Ann Machado - Re: Permit #2014-00180 - solar electric panels for King Middle School

From: Christine Puopolo <christine@revisionenergy.com>
To: Ann Machado <AMACHADO@portlandmaine.gov>
Date: 2/3/2014 4:25 PM
Subject: Re: Permit #2014-00180 - solar electric panels for King Middle School
CC: Jen Hatch <jen@revisionenergy.com>
Attachments: King Middle School Plot Plan.JPG

BOUNDARY LINE RETRACEMENT PLAN FOR HADLOCK FIELD FITZPATRICK STADIUM PORTLAND ICE ARENA PORTLAND EXPOSITION BUILDING KING MIDDLE SCHOOL

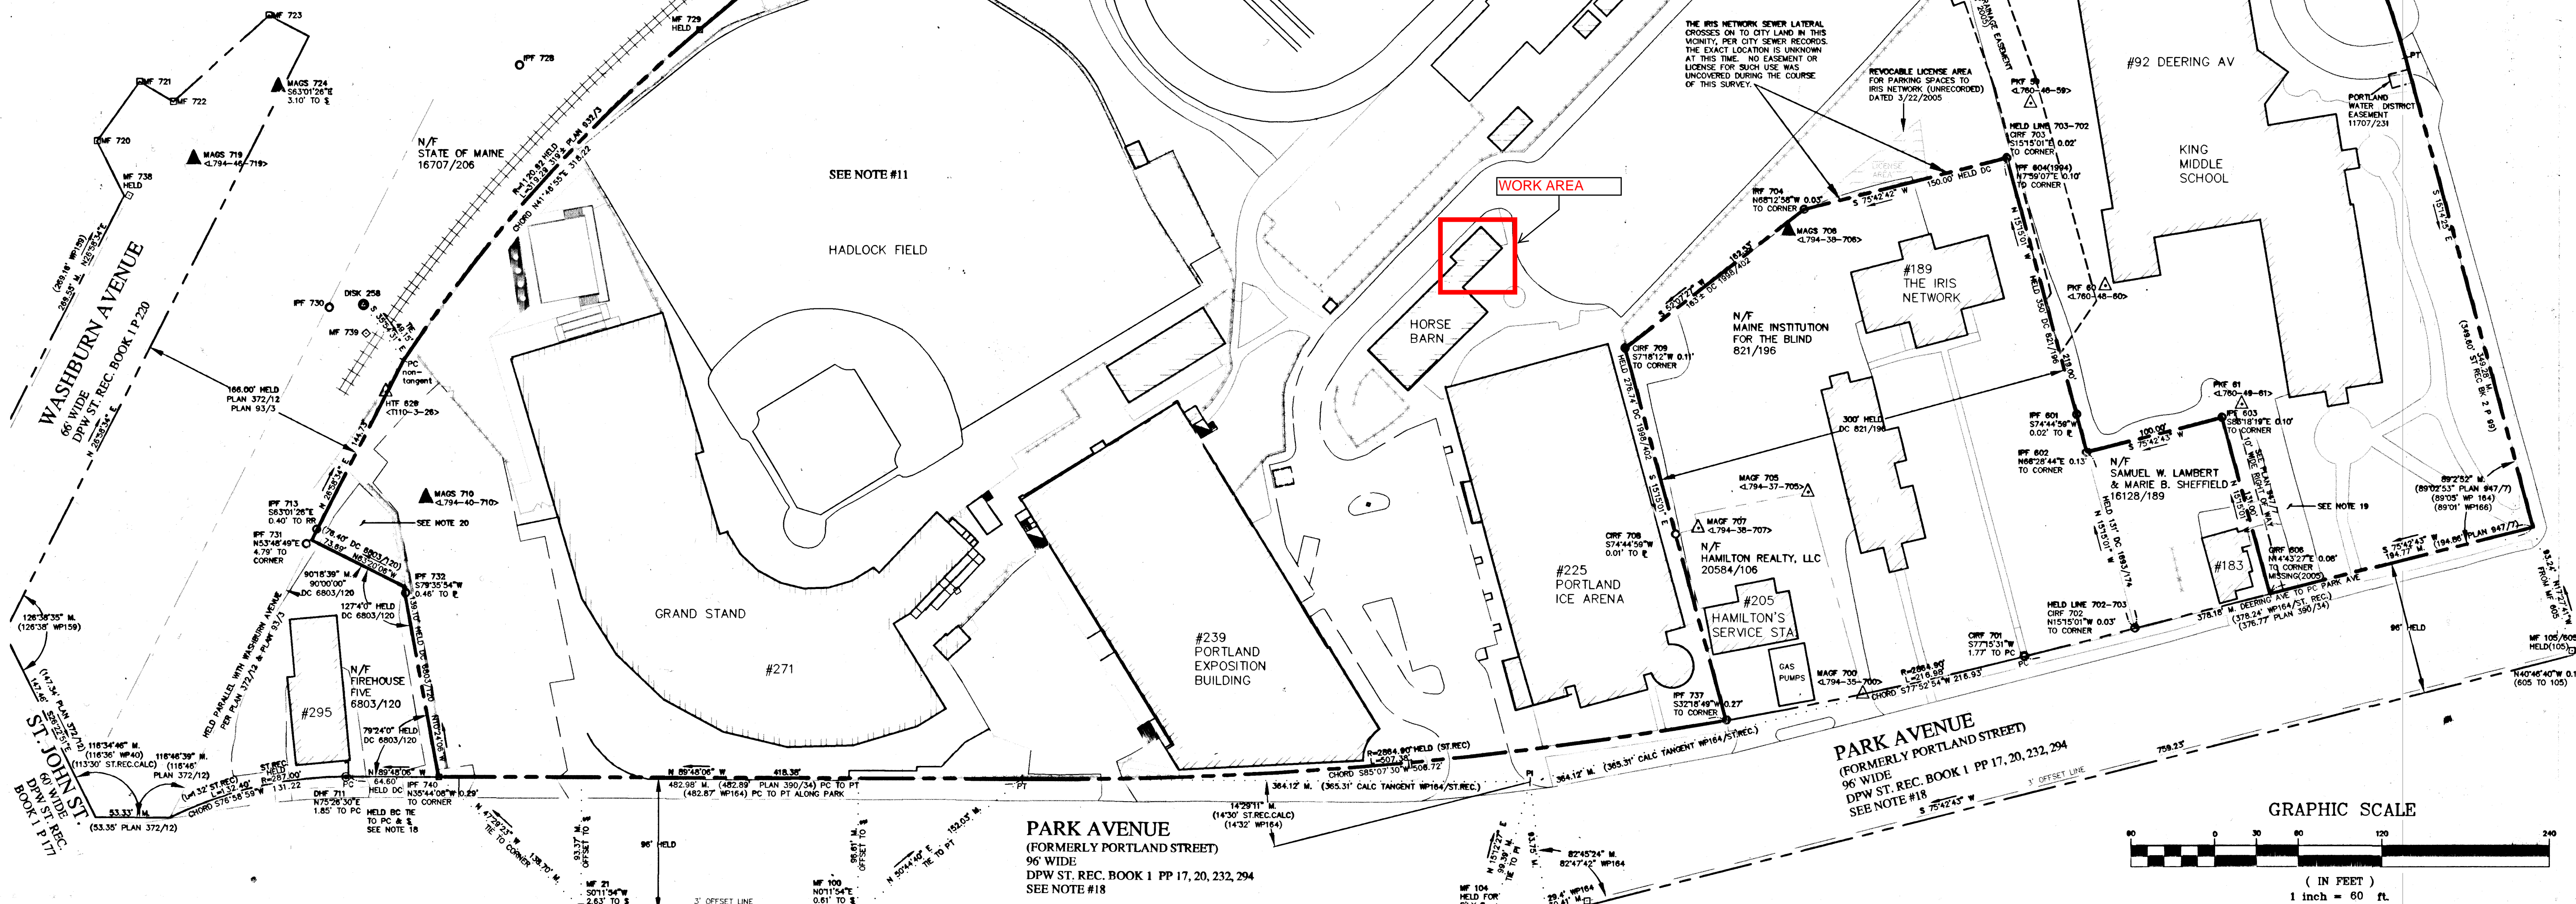
First, you give a rendition of the panels on the wall but we need a key plan of the whole building indicating the location of the wall where the panels are going.

I have attached a plan showing where the panels will be from an aerial view. Let me know if this works for you.
